CITY OF ALBUQUERQUE  
MUNICIPAL DEVELOPMENT DEPARTMENT  
ENGINEERING DIVISION/DESIGN HYDROLOGY SECTION

CONFERENCE RECAP

SUBJECT: Goodwill Industries

RE: DRAINAGE PLAN FOR GOODWILL INDUSTRIES  
(J-22/D53) RECEIVED MARCH 14, 1986

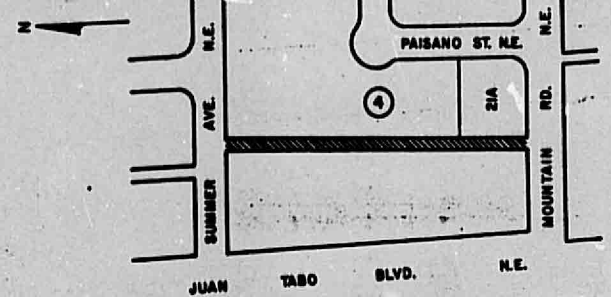
Based on the information provided on your March 14, 1986 submittal, we will need a copy of the P-29-159 so that we can evaluate the alley conditions.

Attached you will also find a copy of the alley grades. The area of concern is circled. As you can see, if the City was to go in and pave the alley, the dip portion would be filled in. I feel that this in itself might cause you problems.

# GRADING AND DRAINAGE PLAN FOR GOODWILL INDUSTRIES PARCEL "B" BLOCK 4 ROYAL HEIGHTS ADDITION

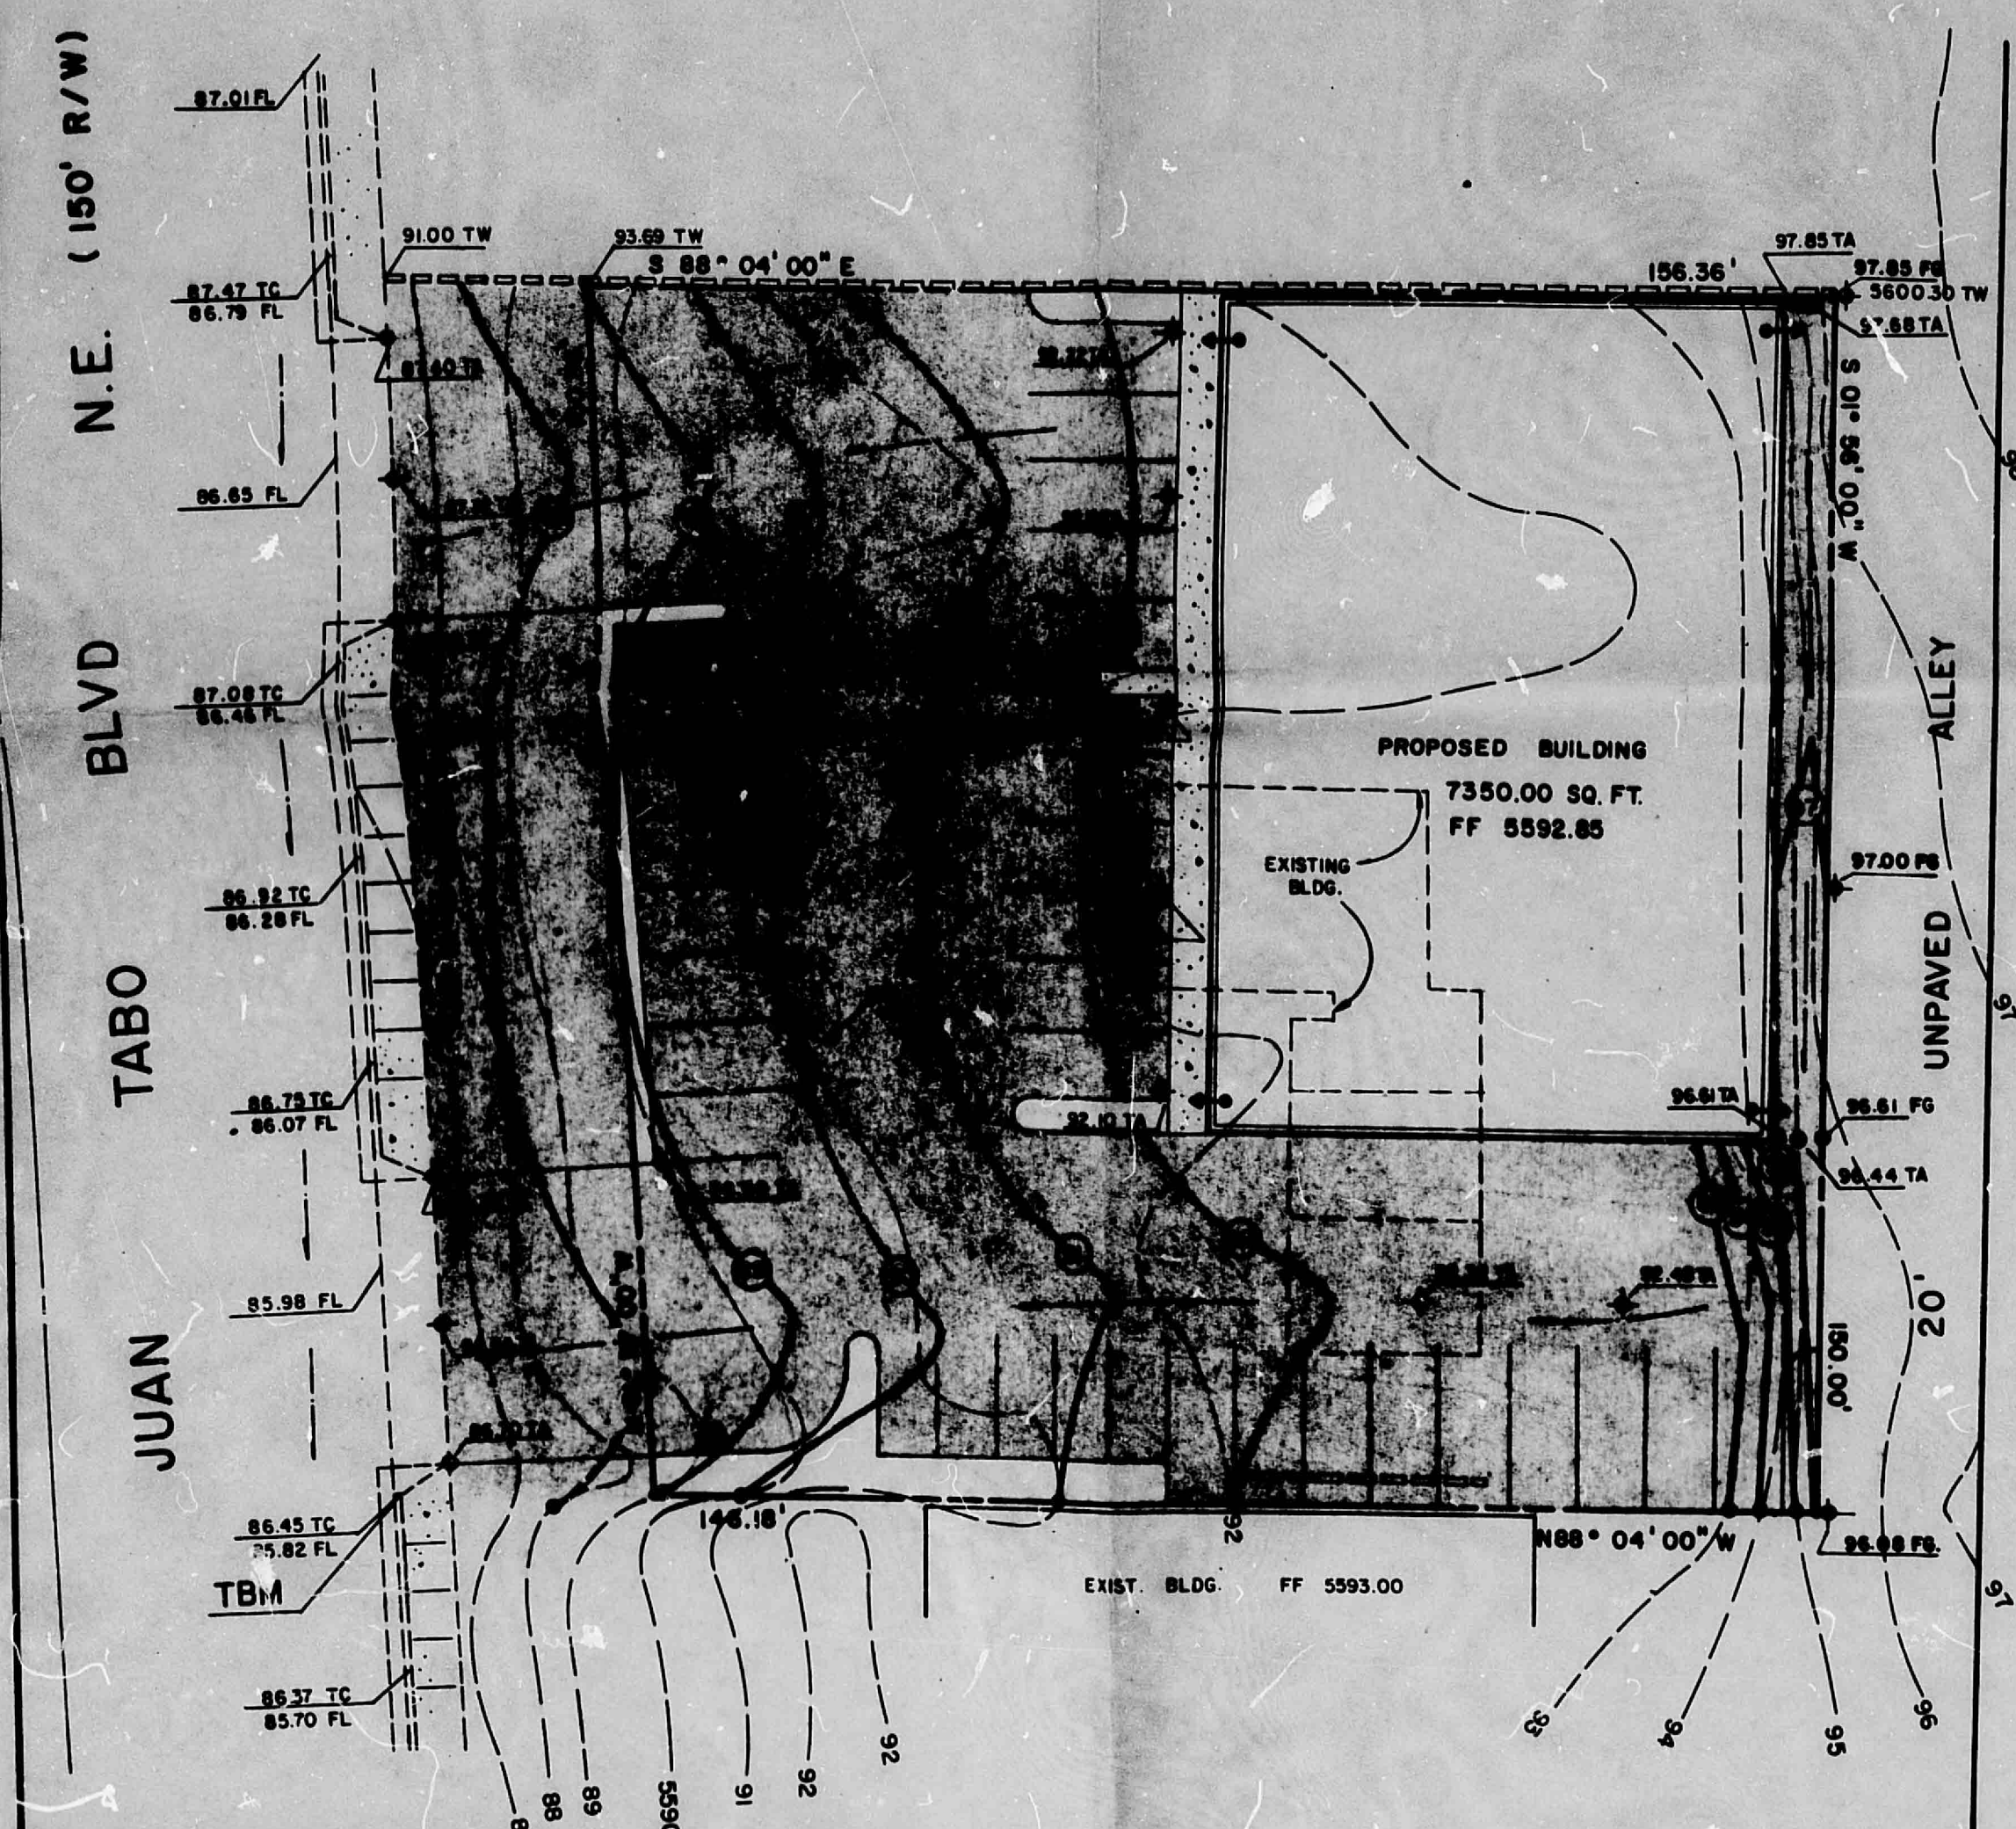
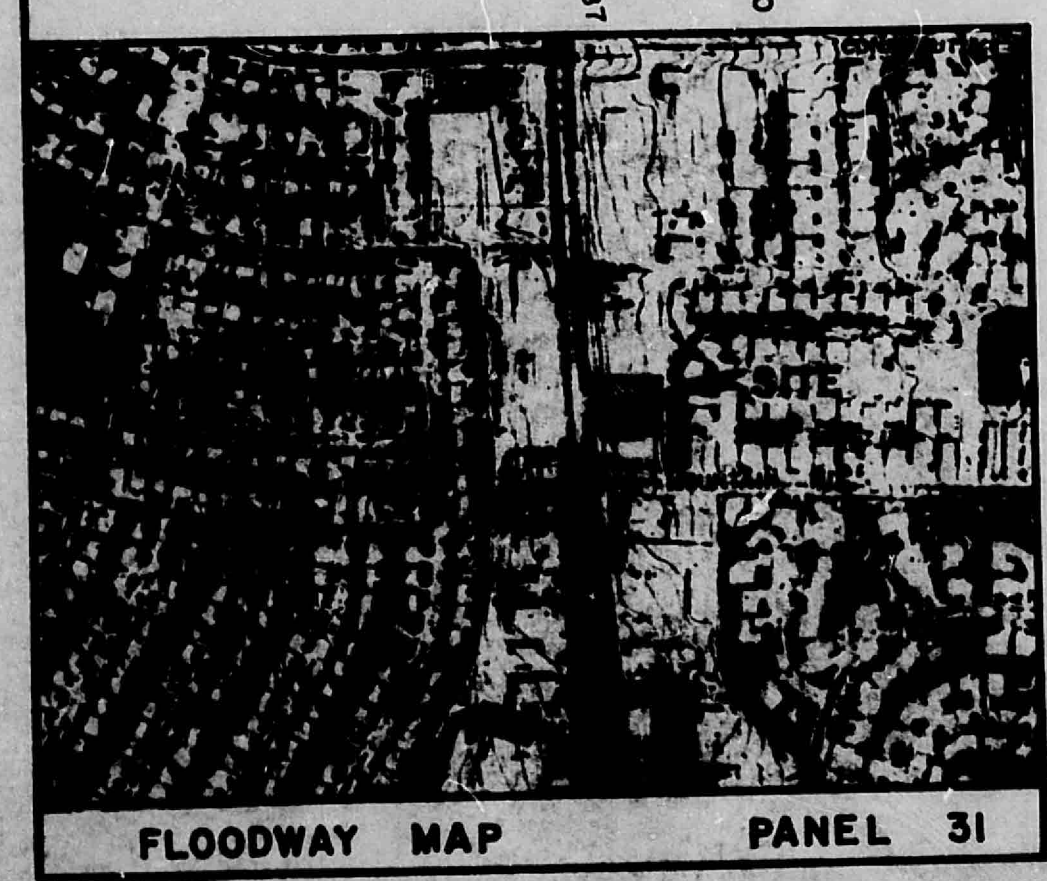
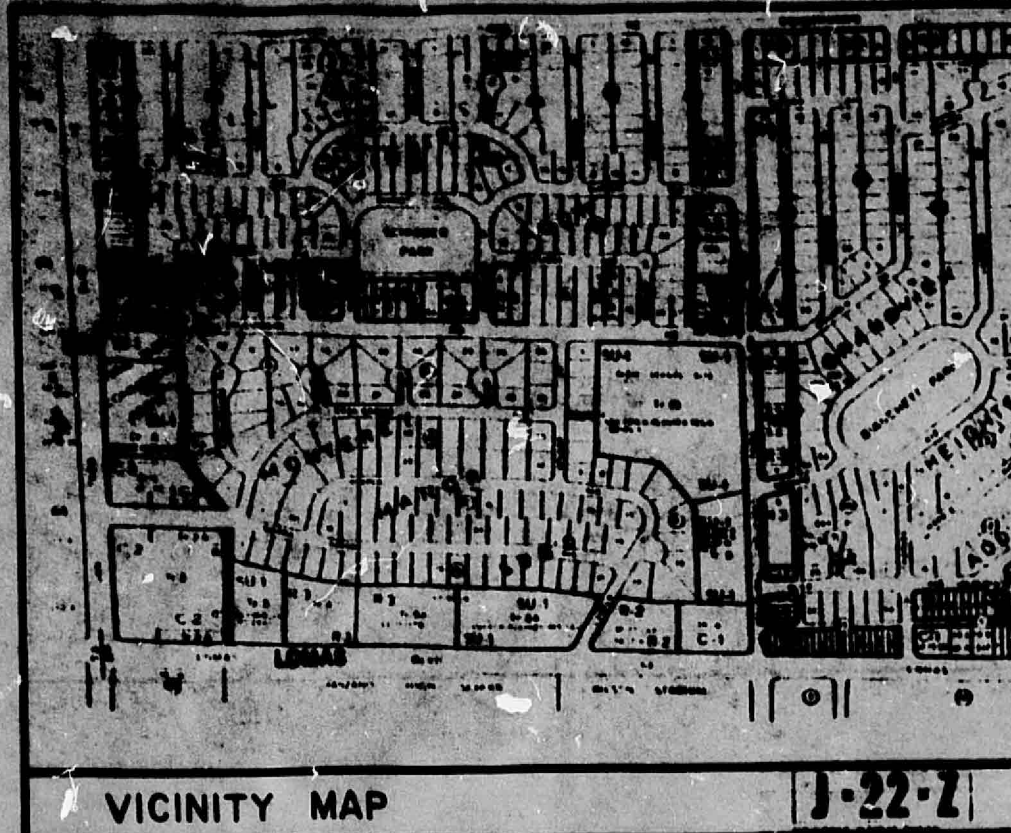
- ① Replat is required to remove lotlines.
- ② Direct discharge to the existing storm sewer system is recommended. If surface discharge is preferred by design, on-site control will be required.
- ③ An approved erosion control plan is required for the period of construction to ensure that sediments remain on-site.
- ④ City approved alley grades are required for sign-off at C.D.

Please be advised that the alley cannot be used for access into or out of the proposed site without paving the portion of alley involved.
